**MARYSVILLE**  
**COMMUNITY**  
**DEVELOPMENT**

March 15, 2022

Re: Gemmer PRD, 1125 & 1507 172<sup>nd</sup> Street NE (PA22-007)

<sup>1</sup> Gemmer PRD, first technical review comments (PA22-007)

SHEET
P1 of P6
24x36
PA22-007

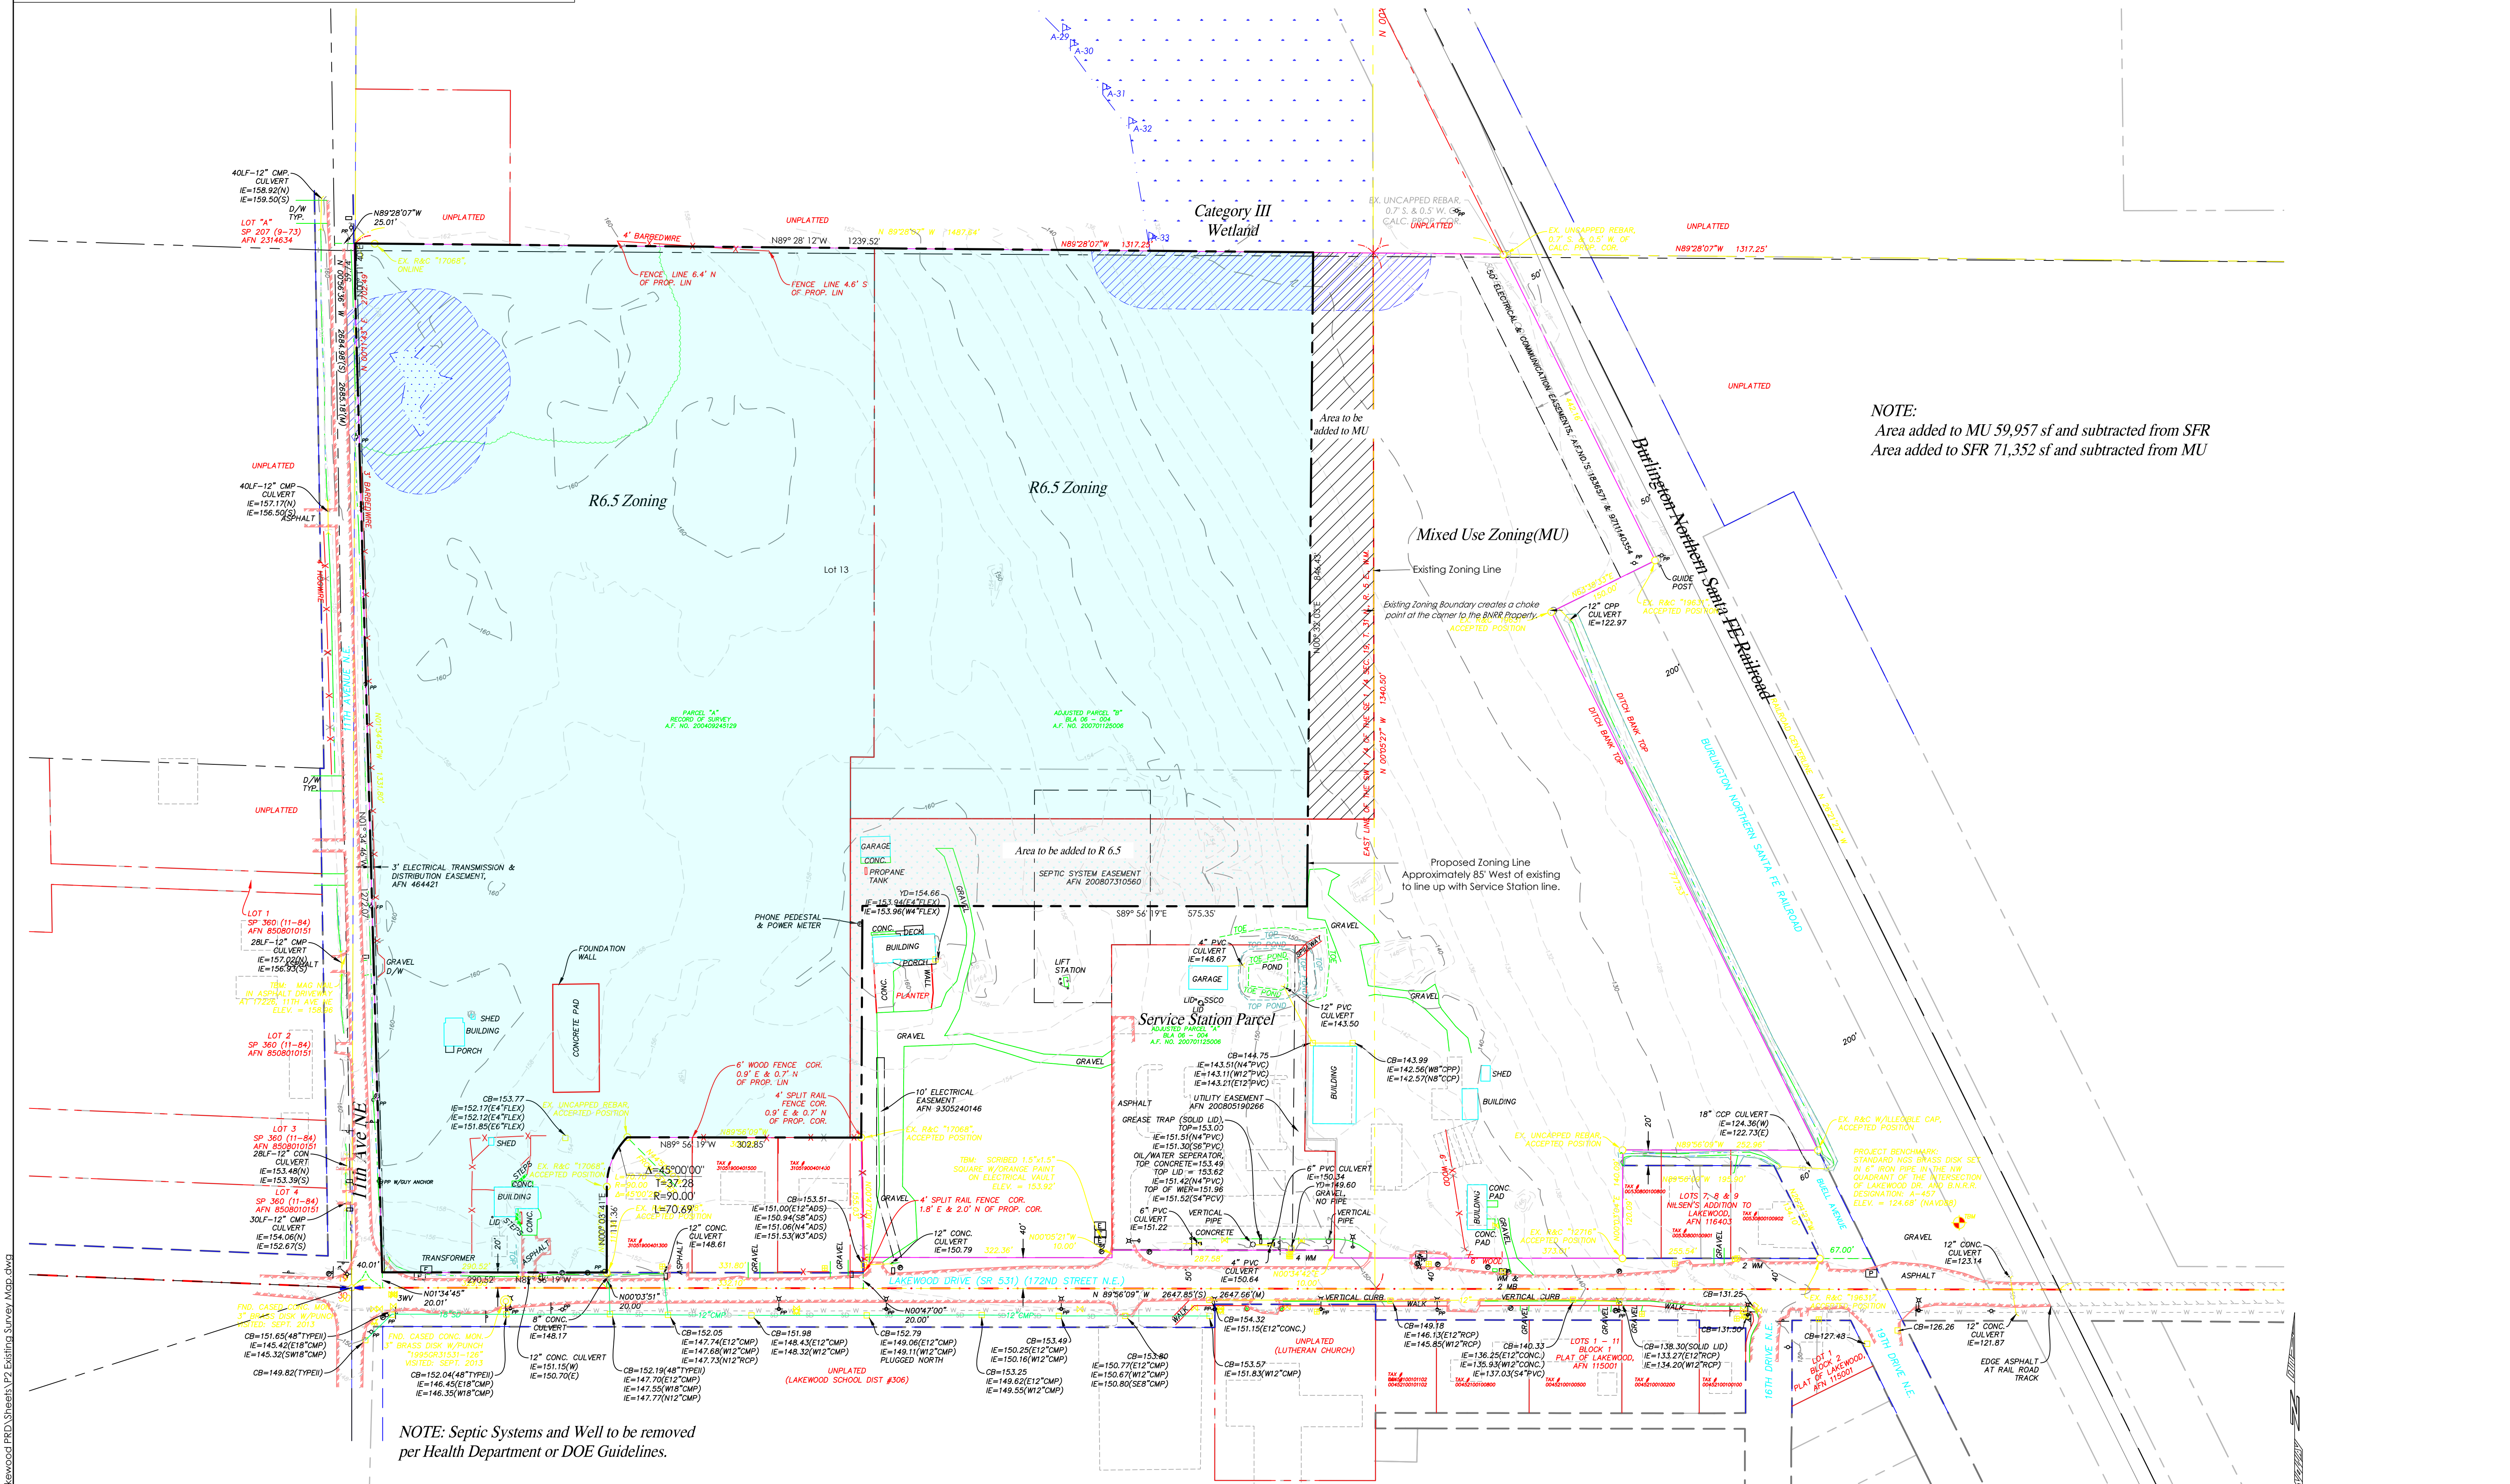
3. Please remove file number PreA21-050 on all sheets and replace with PA22-007.
4. The guest parking spaces located on the curve of road A shall be eliminated (spaces G197-208) as it does not meet MMC 22G.080.080(2)(b)(iv), and may cause safety/sight distance issues.

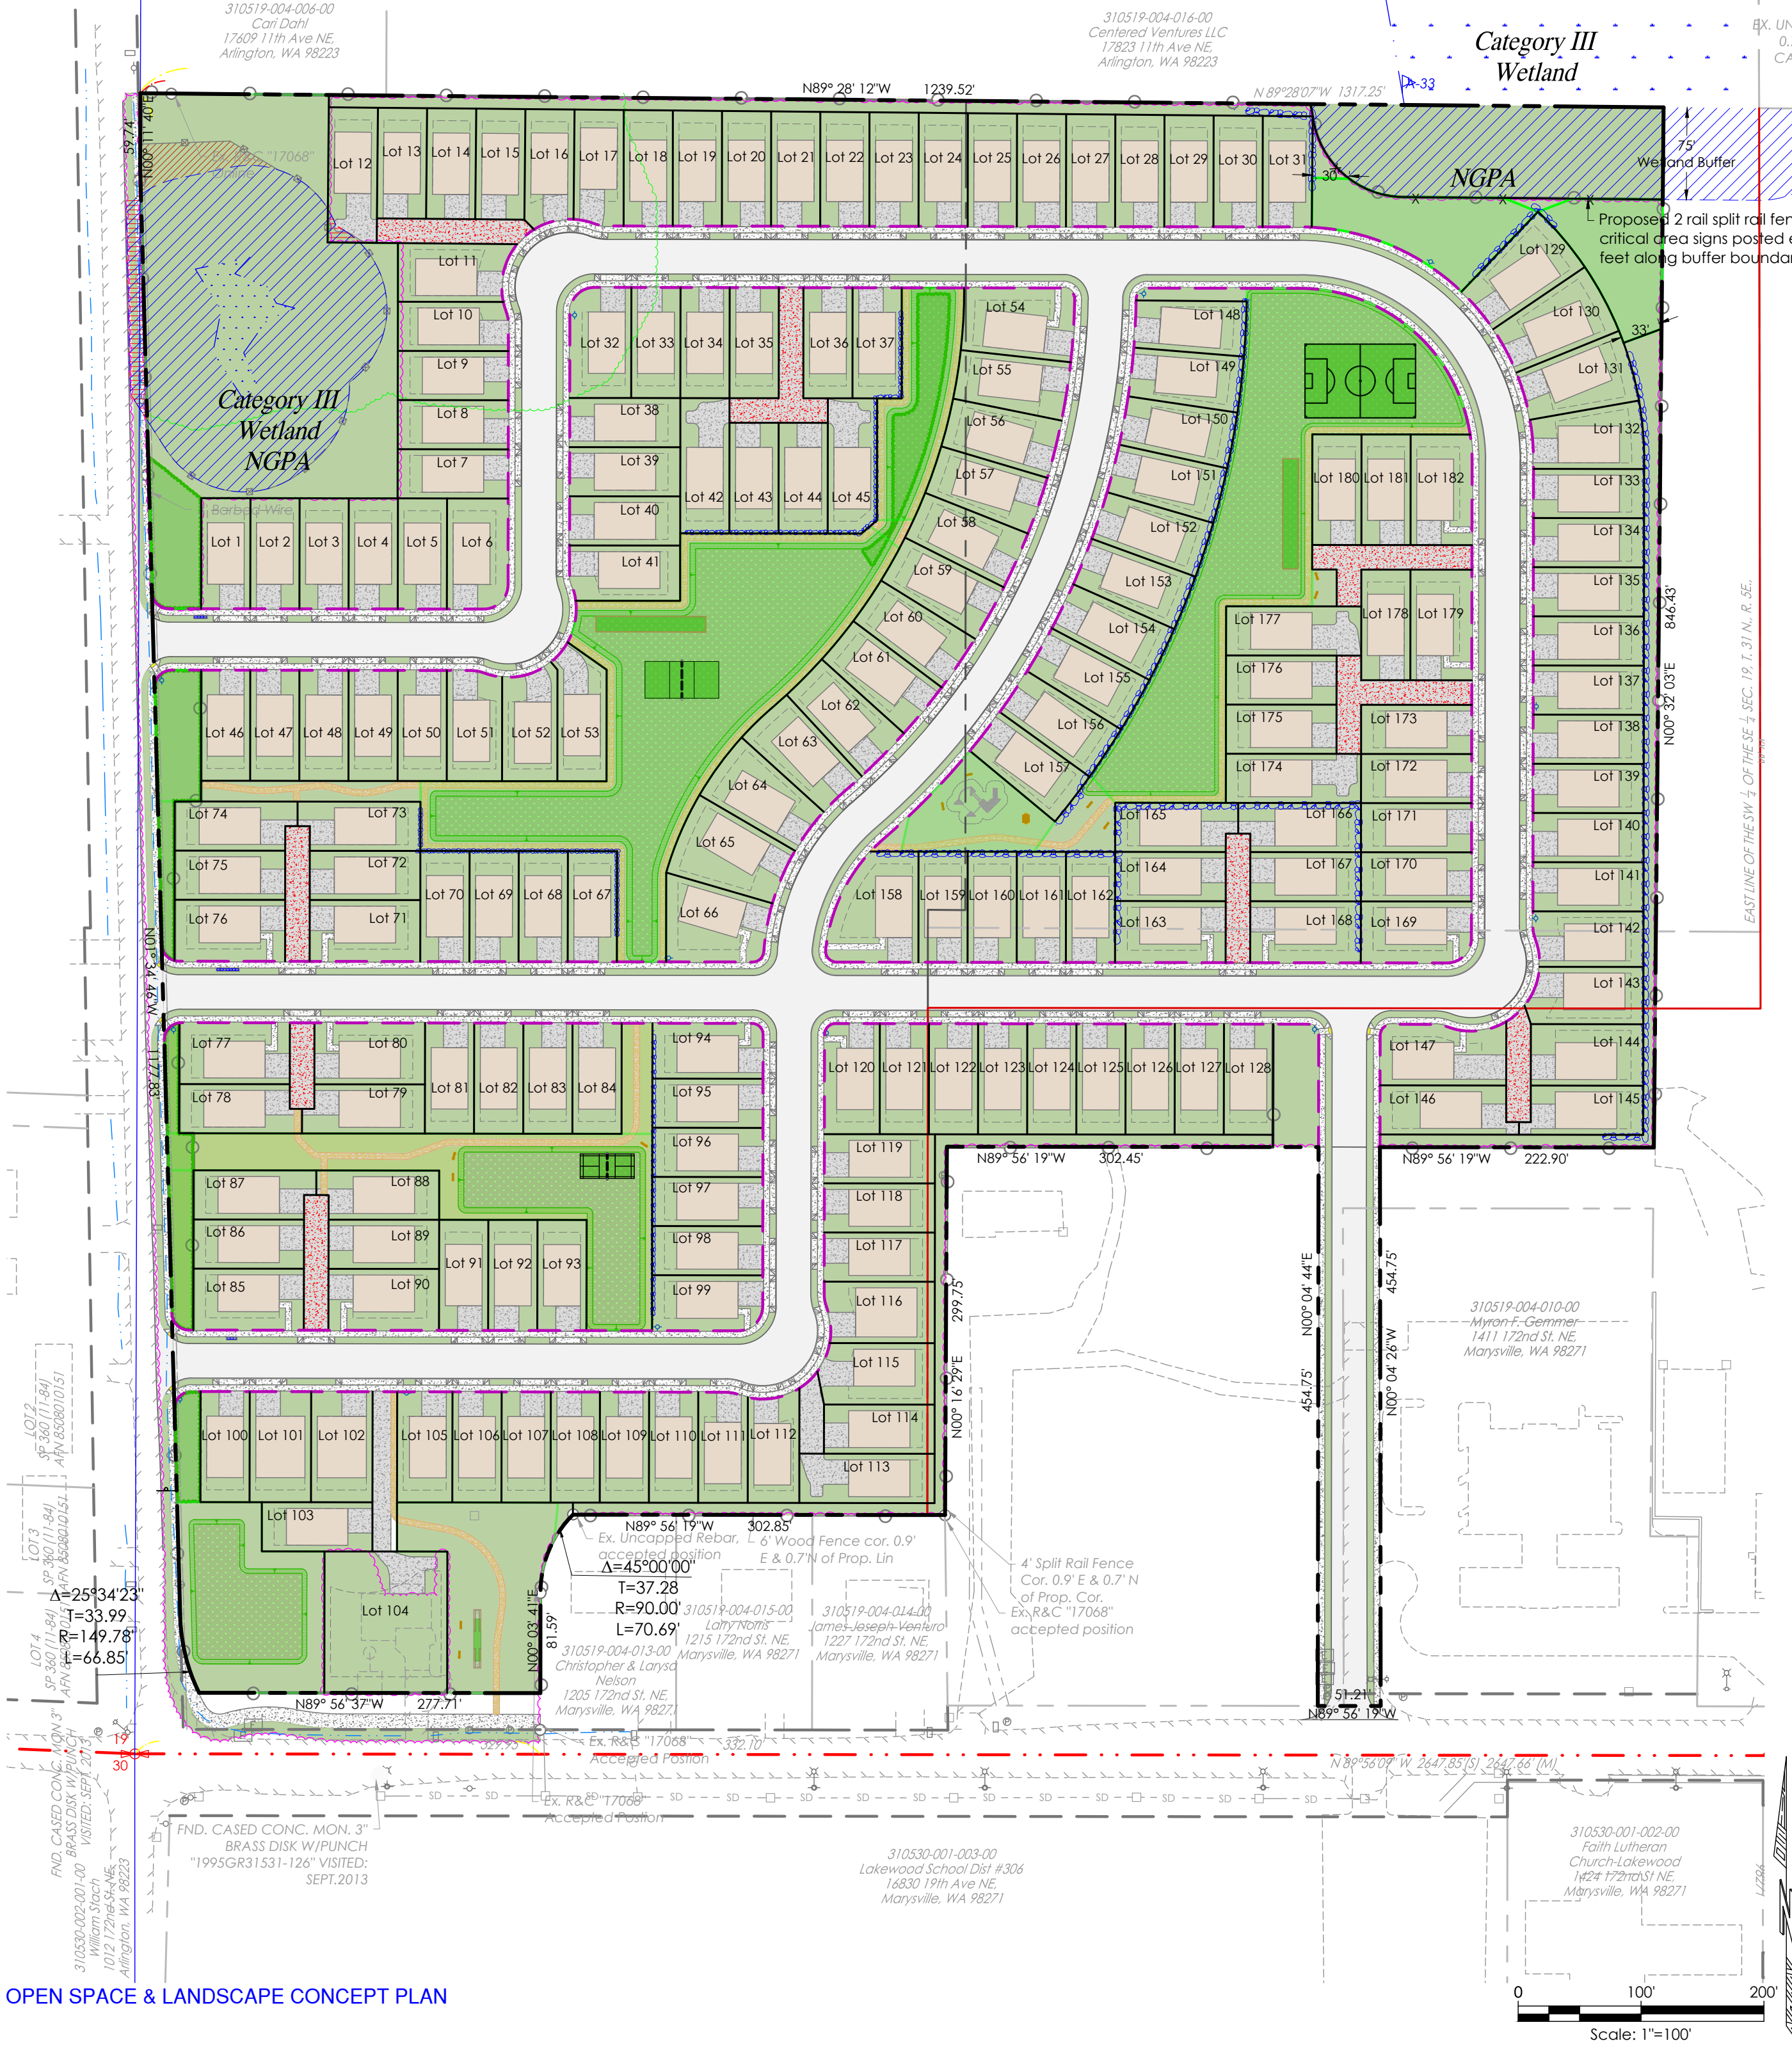
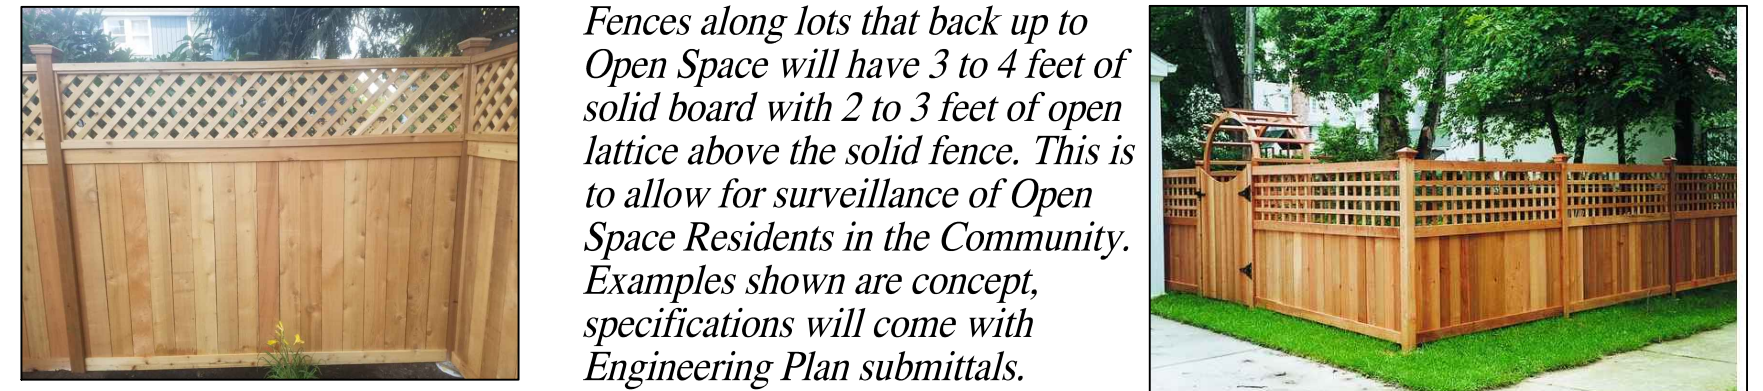
9. Pursuant to MMC 22G.080.100(4)(e), open space shall include a minimum of one large recreational amenity or two small recreational amenities per one-quarter acre of active recreation space. Small recreational amenities include commercial-grade benches, picnic tables, small play equipment, and similar amenities. Large recreational amenities include

commercial-grade half sport courts, large play equipment, gazebos, and similar amenities. Please provide the total number of large and small amenities to be provided.
